ABP— 314485-22

For the attention of inspectors assessing Bord Pleanala Case Ref : PL06F.314485

This document is submitted by Myles Caulfield Hon Secretary of River Valley and Rathingle Residents Association, which is the largest residential estate nearest the Dublin Airport.

Figure 14D-1: Ground noise baseline survey locations

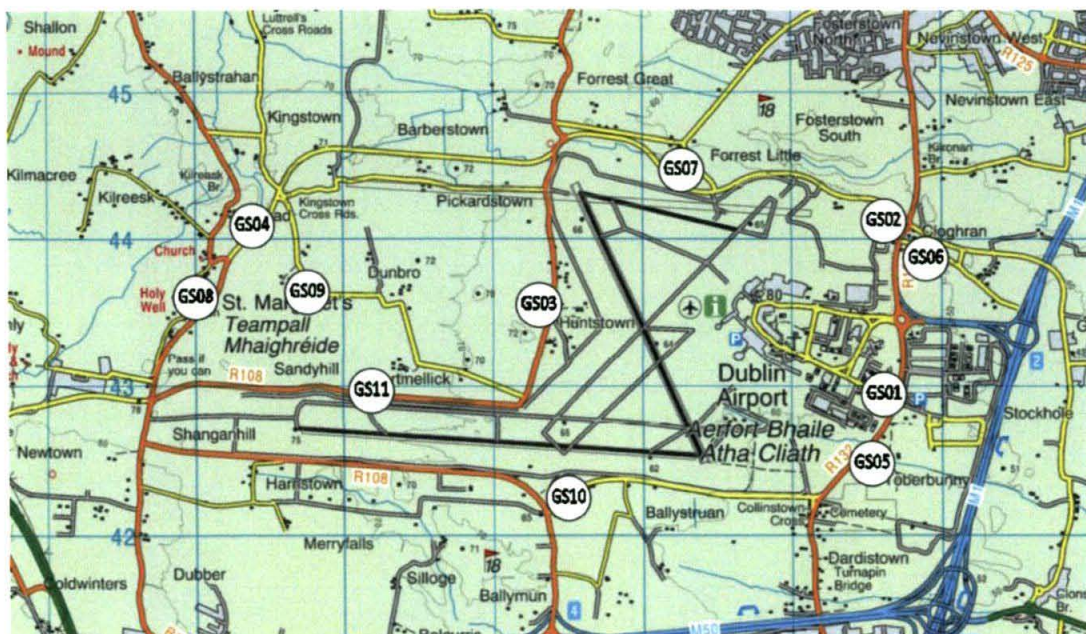
Chapter 13 of the Daa sponsored environment impact assessment report attempts to focus without distinction on airborne & "ground noise" for aircraft "while using the runway system". However, the "ground noise" measurements presented as relevant were taken before the new runway commenced and the predicted "future" model conclusions have not been validated against current South Swords full operational ground noise data. Hence, any conclusions drawn from these models are palpably unsafe.

Chapter 14 of the DAA sponsored environment impact assessment report attempts to focus on "basic" ground noise "as mainly aircraft taxiing and aircraft using auxiliary power units". This analysis is based on even older data before operations on the new runway commenced, appears to ignore the primary ground noise source for South Swords being aircraft in take-off mode and ignores completely the radically changed noise dynamic of dual runway operations. As a result any conclusions based on this data are also completely irrelevant for South Swords.
